## MEMORANDUM

Subject: **Raising Cane's 4800 Montgomery Blvd. NE**  
Erosion and Sediment Control Plan  
*Engineer's Stamp Date 4/4/2022 (G17E011)*

The intent of this memo is to provide responses to Correction Notice #1 of the Project Raising Cane's 4800 Montgomery Blvd. NE, submitted to One Albuquerque Planning. Please find the corrections listed below with our response to corrections in **bold**.

Date: 05.12.2022

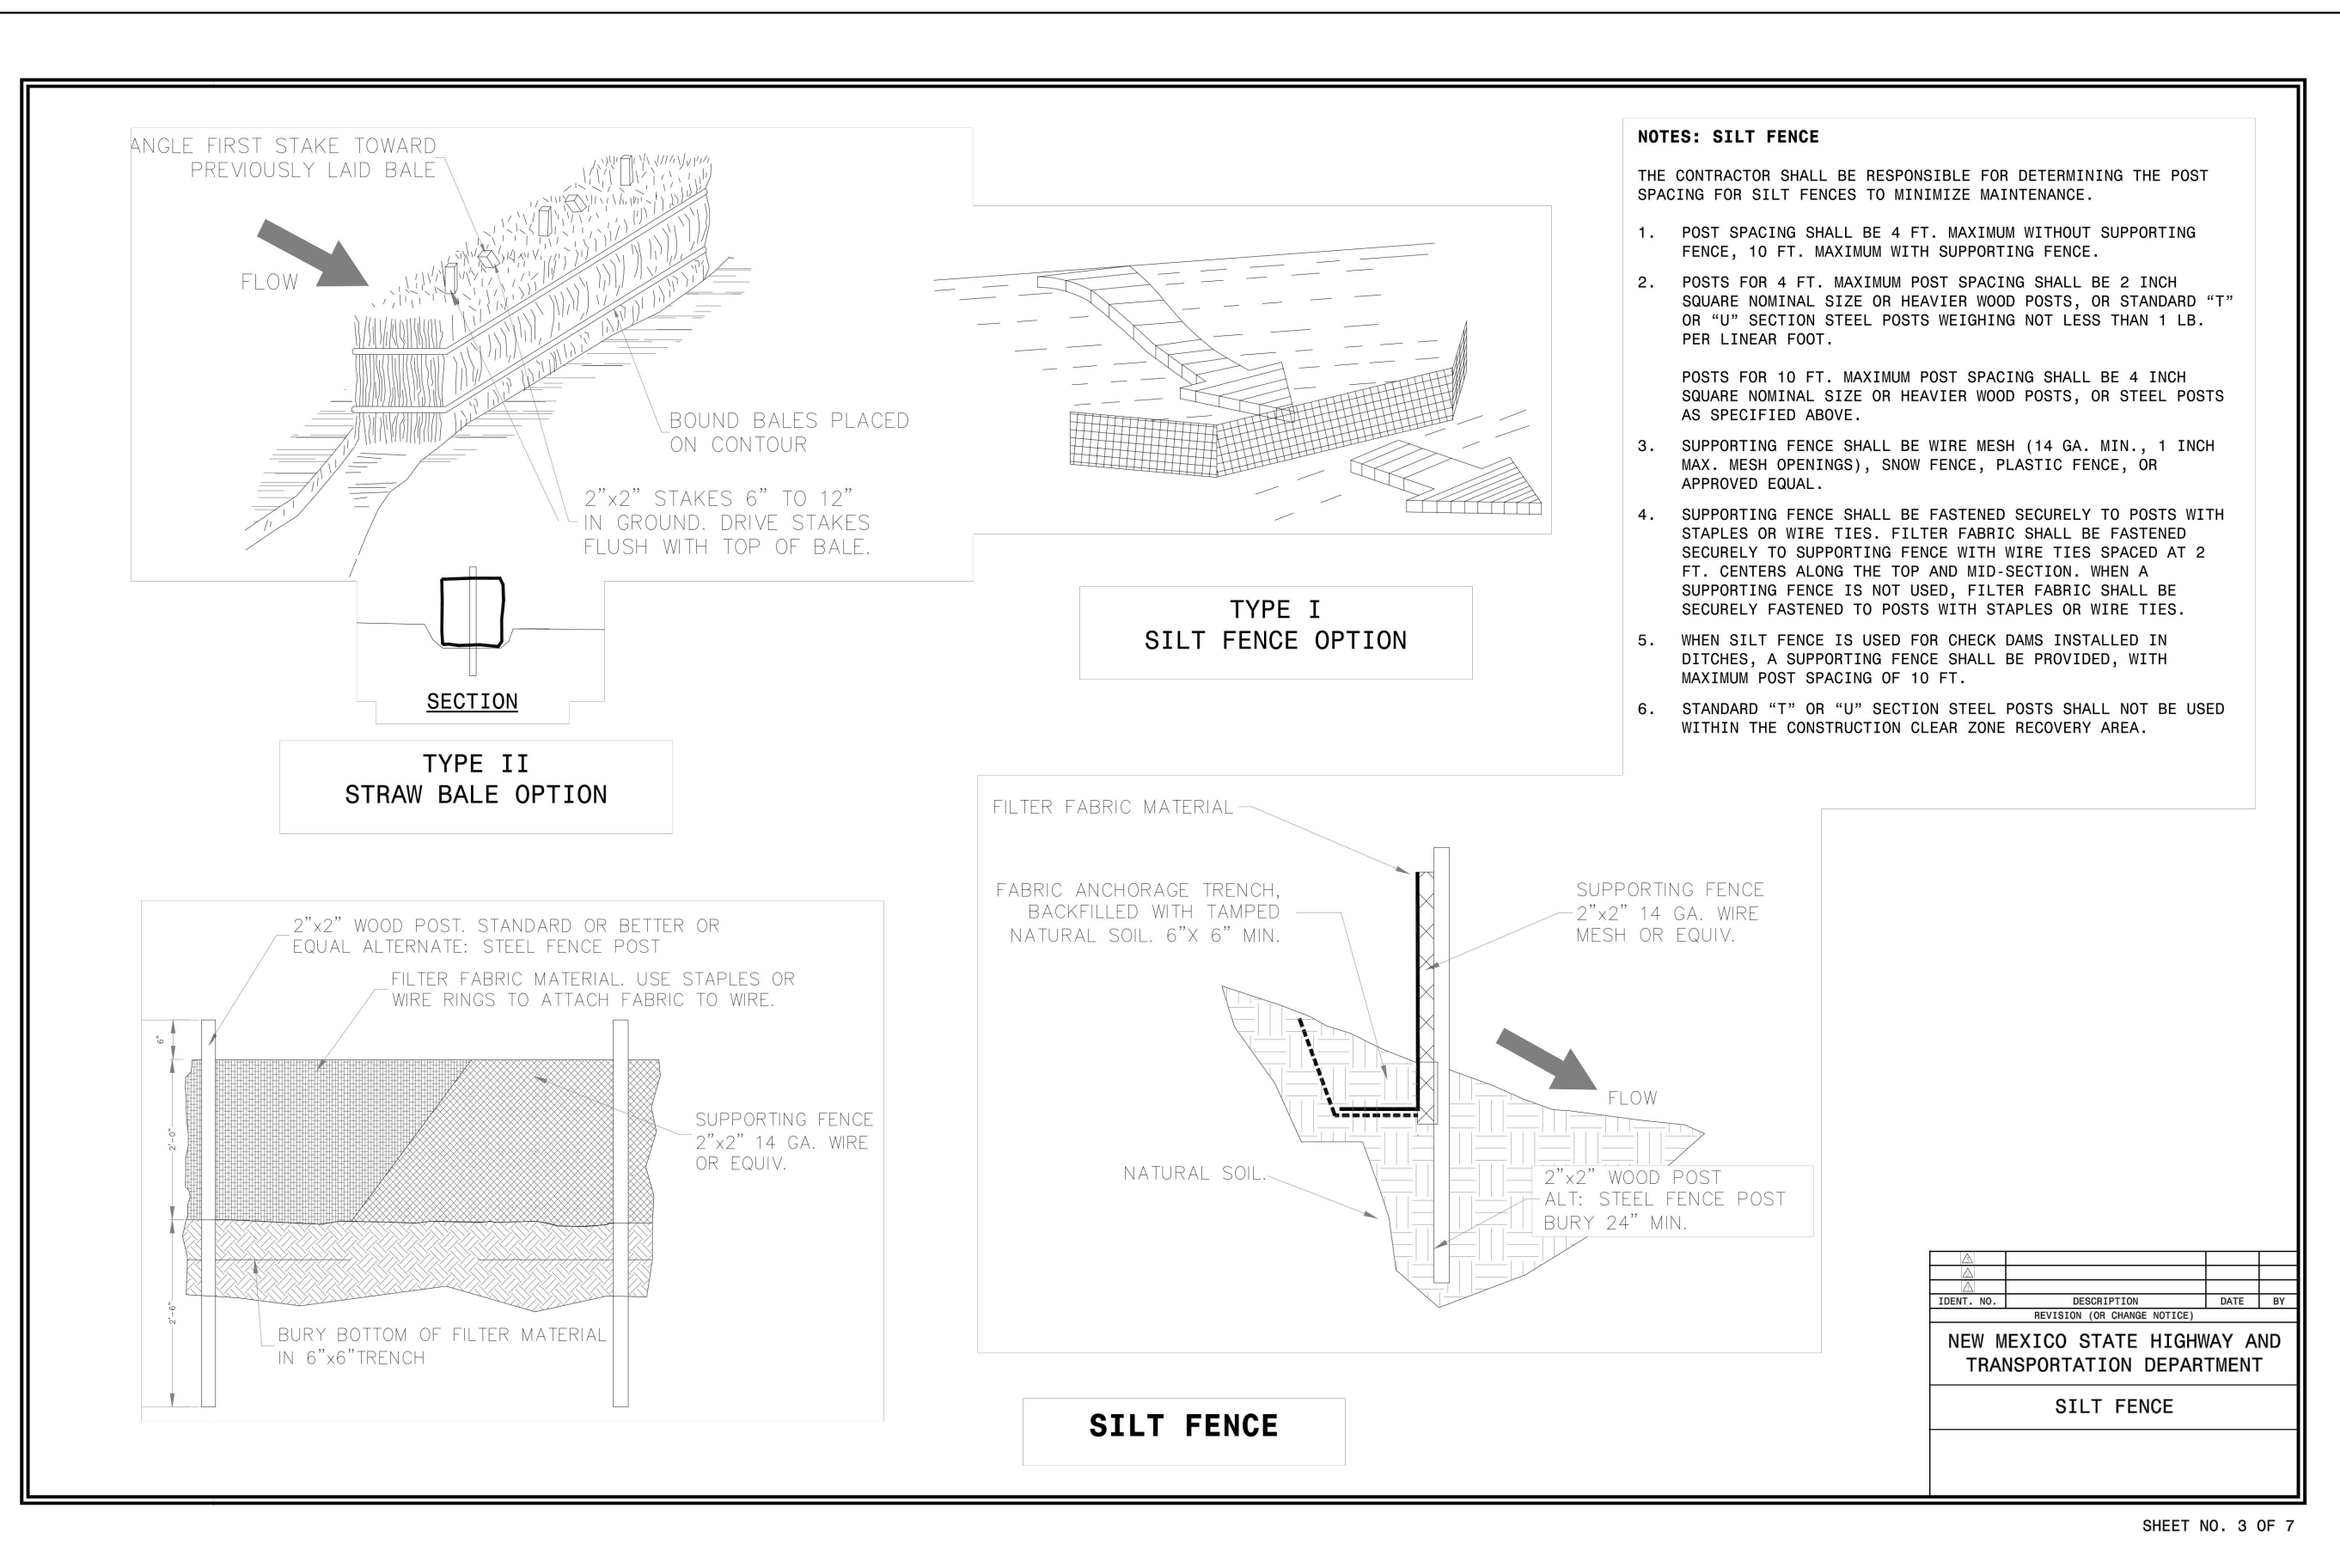
5. Update engineer's stamp date each time the plan is changed

**The Engineer's stamp date has been updated. See civil sheets for update.**
